**RE: Ladera Self Storage
2100 Ladera Dr. NW
Temporary C.O. - Accepted
Engineer's Certification Date: 08/02/19
Engineer's Stamp Date: 07/31/18
Hydrology File: H09D001F**

Based on the Certification received 08/06/2019 and site visit on 08/09/19, this certification is approved in support of Temporary Release of Occupancy by Hydrology. The following comment needs to be addressed prior to acceptance for Permanent C.O. of the above referenced project:

C.01

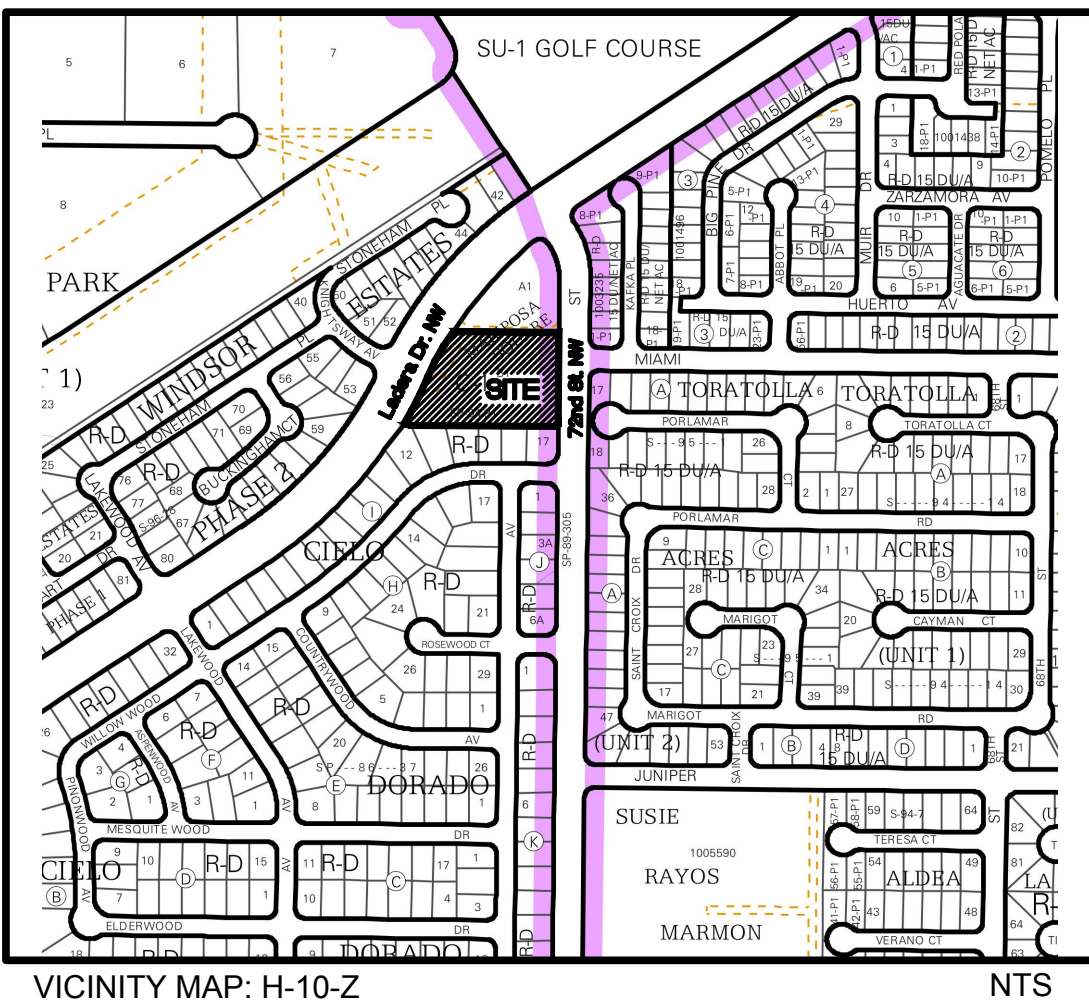
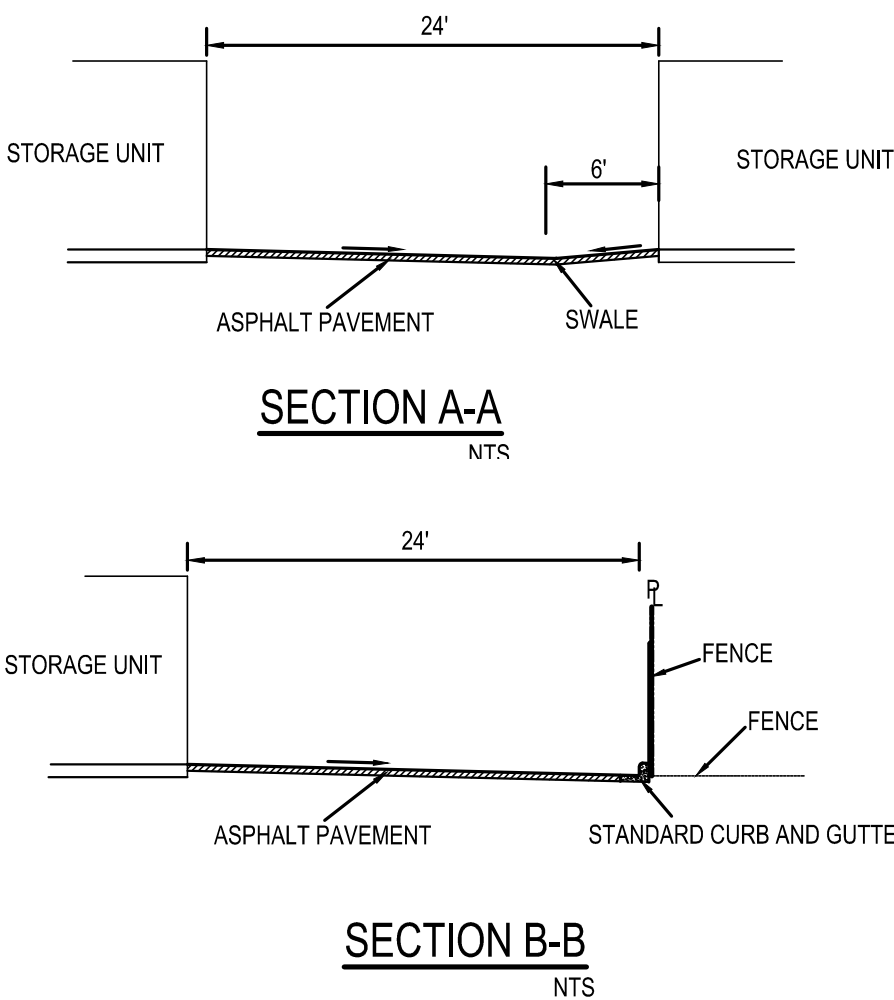
1. The sidewalk culvert on 72nd Street needs to be brought up to City standards and follow the City of Albuquerque Standard Drawing No. 2236. (See attachment) Once complete, the Contractor must contact Augie Armijo at (505) 857-8607 and Construction Coordination at 924-3416 to schedule an inspection. I will need an ok from Augie prior to issuing the Permanent C.O.
